Engineers Comments Regarding Surface Water Drainage

APPLICATION NO: BN/22/20/PL

Site Address: Land South West of 40 Hill Lane Barnham PO22 0BL

Description of Works: Remove existing polytunnels & creation of sand school with new native tree & hedge planting.

Drawing No. DPA-01	Revision 03
-----------------------	----------------

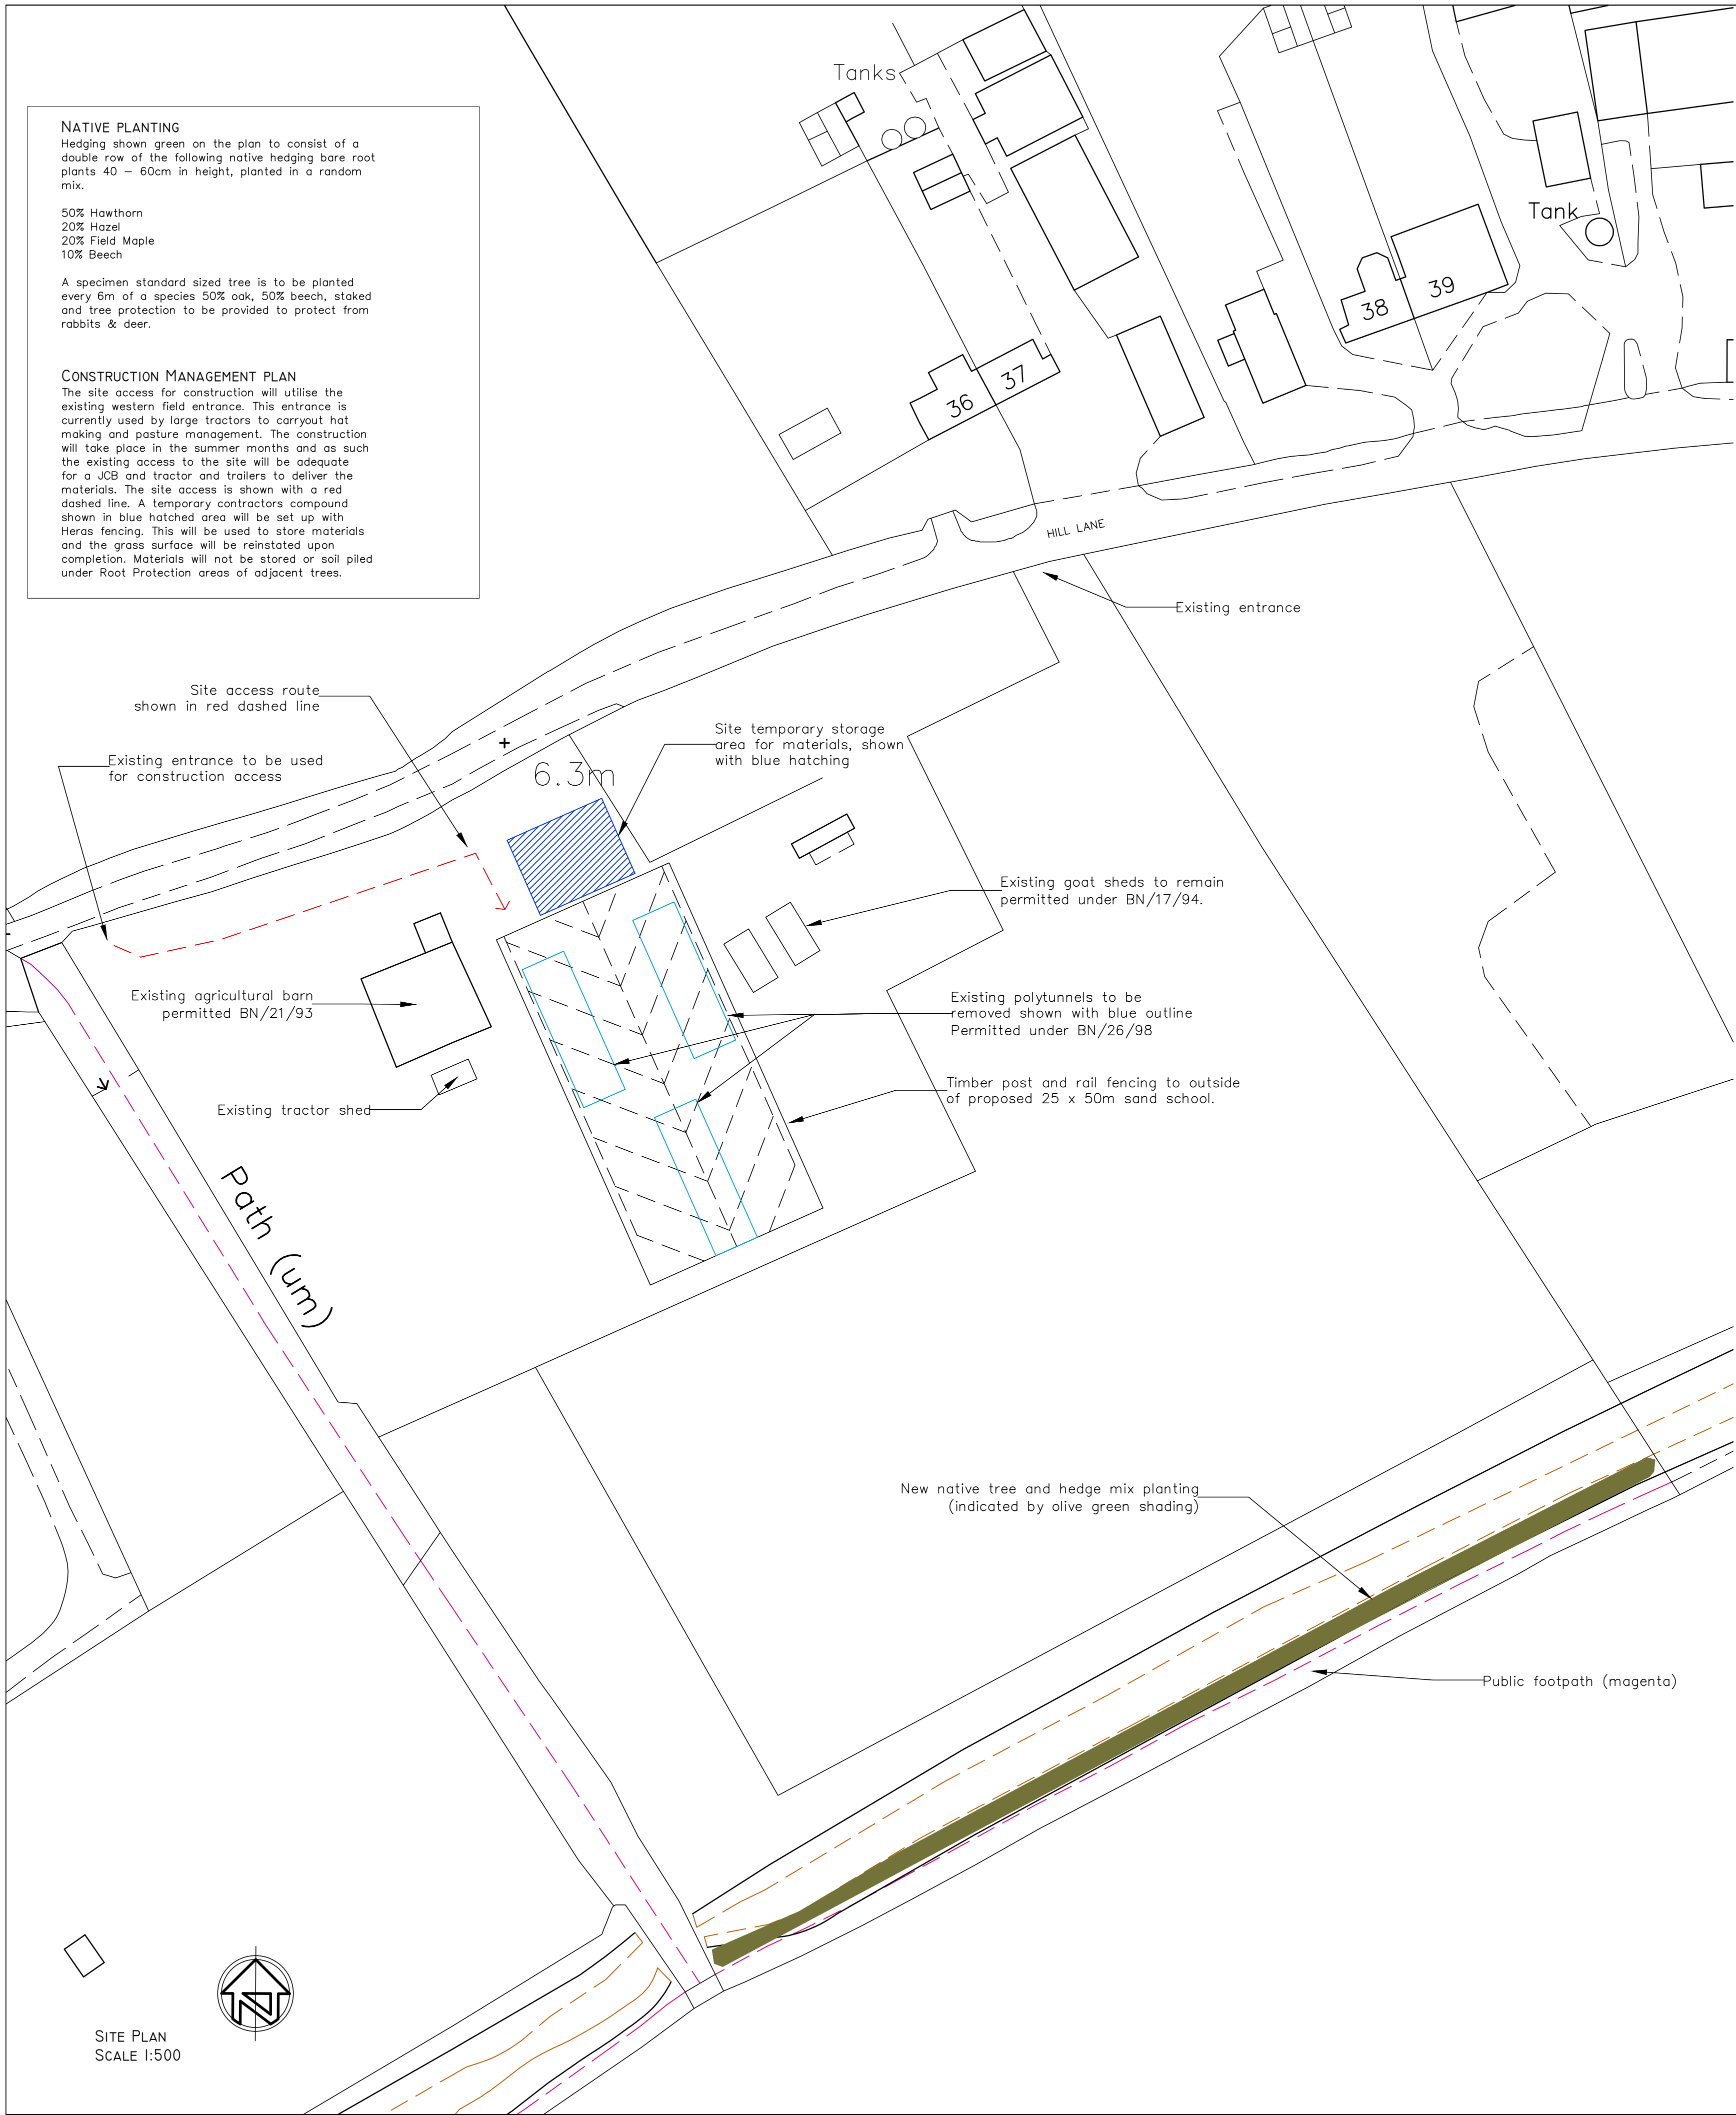
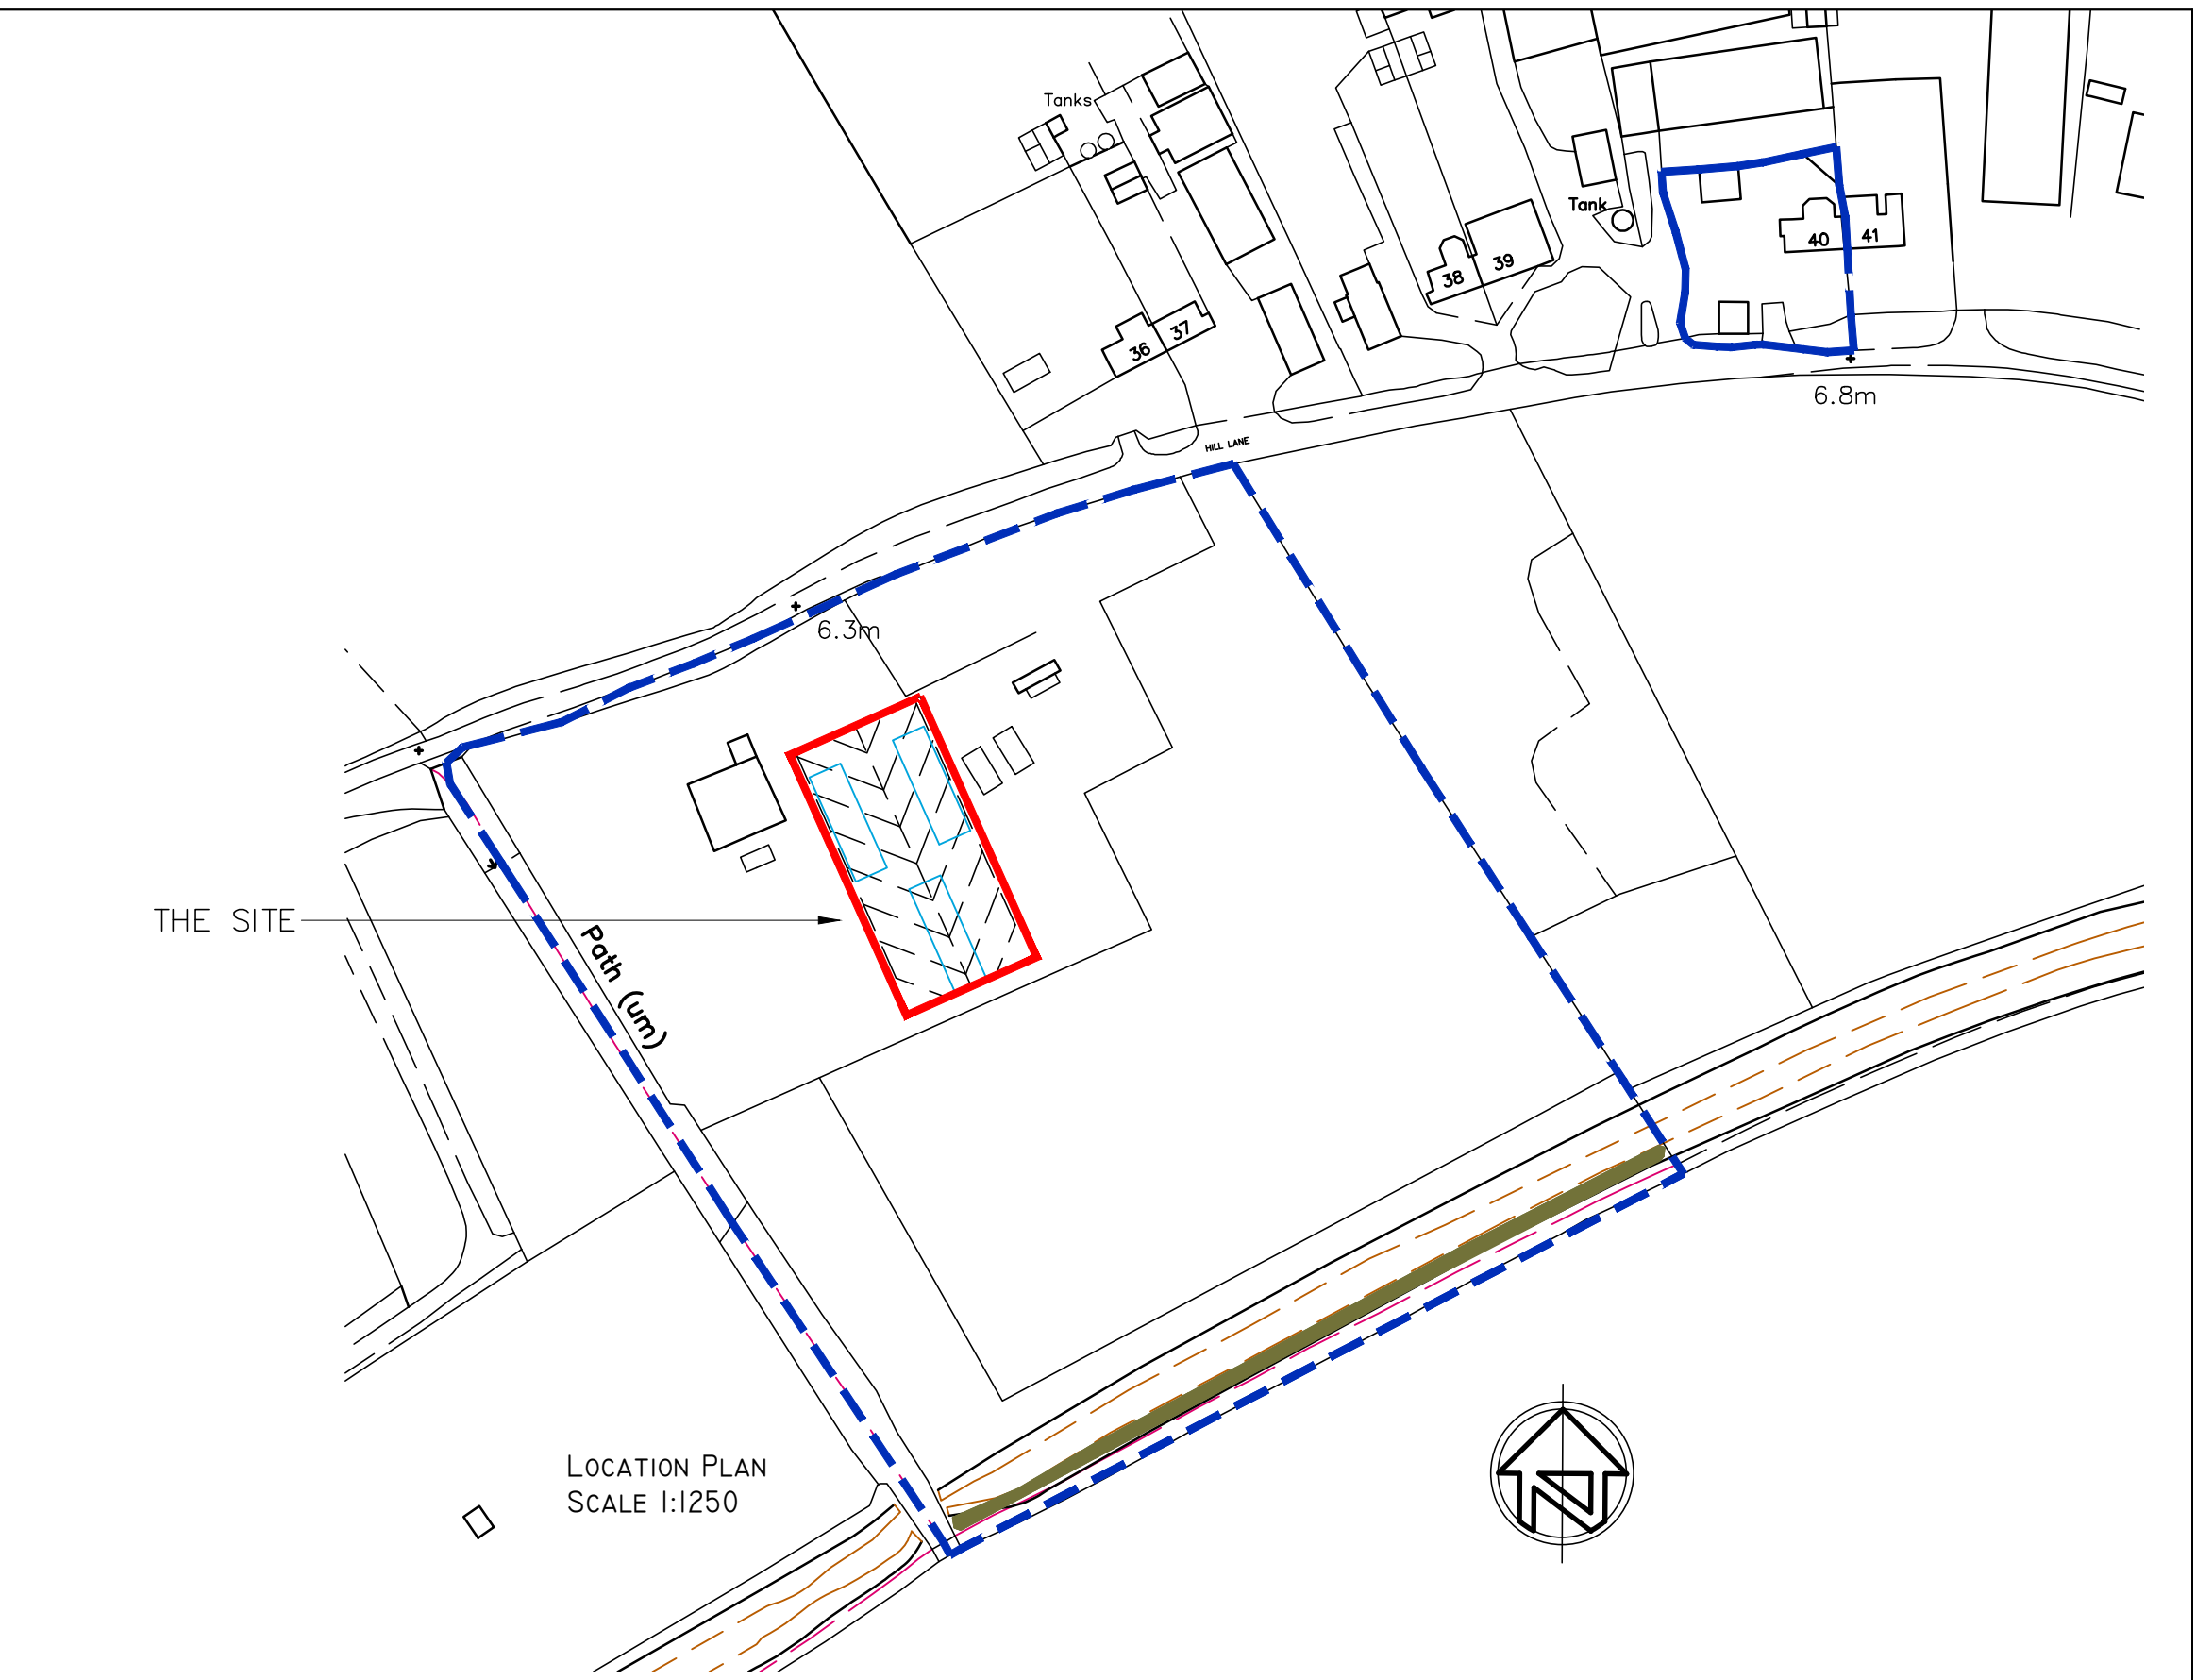
The application is within the Lidsey Treatment Catchment, therefore surface water drainage design should be carefully considered. The site plan and section detail show a series of perforated pipes with no drainage layout or design to show how the 1250m² training school will be drained. The applicant has stated in the application that the school shall be drained by infiltration under the structure, however no infiltration testing has been completed to show that this is viable and the need for the perforated pipes is questioned if this is the proposed strategy.

In addition, there is a watercourse running along the northern boundary of the site. The proposed planting must not have a detrimental effect on the Hill Lane ditch and culvert. It is suggested that the Tree Officer is consulted to ensure that the proposed species, and their location will not impact upon this drainage network.

"Development shall not commence, other than works of site survey and investigation, until full details of the proposed surface water drainage scheme have been submitted to and approved in writing by the Local Planning Authority. The design should follow the hierarchy of preference for different types of surface water drainage disposal systems as set out in Approved Document H of the Building Regulations, and the recommendations of the SuDS Manual produced by CIRIA. Winter groundwater monitoring to establish highest annual ground water levels and winter Percolation testing to BRE 365, or similar approved, will be required to support the design of any Infiltration drainage. No building / No part of the extended building shall be occupied until the complete surface water drainage system serving the property has been implemented in accordance with the agreed details and the details so agreed shall be maintained in good working order in perpetuity."
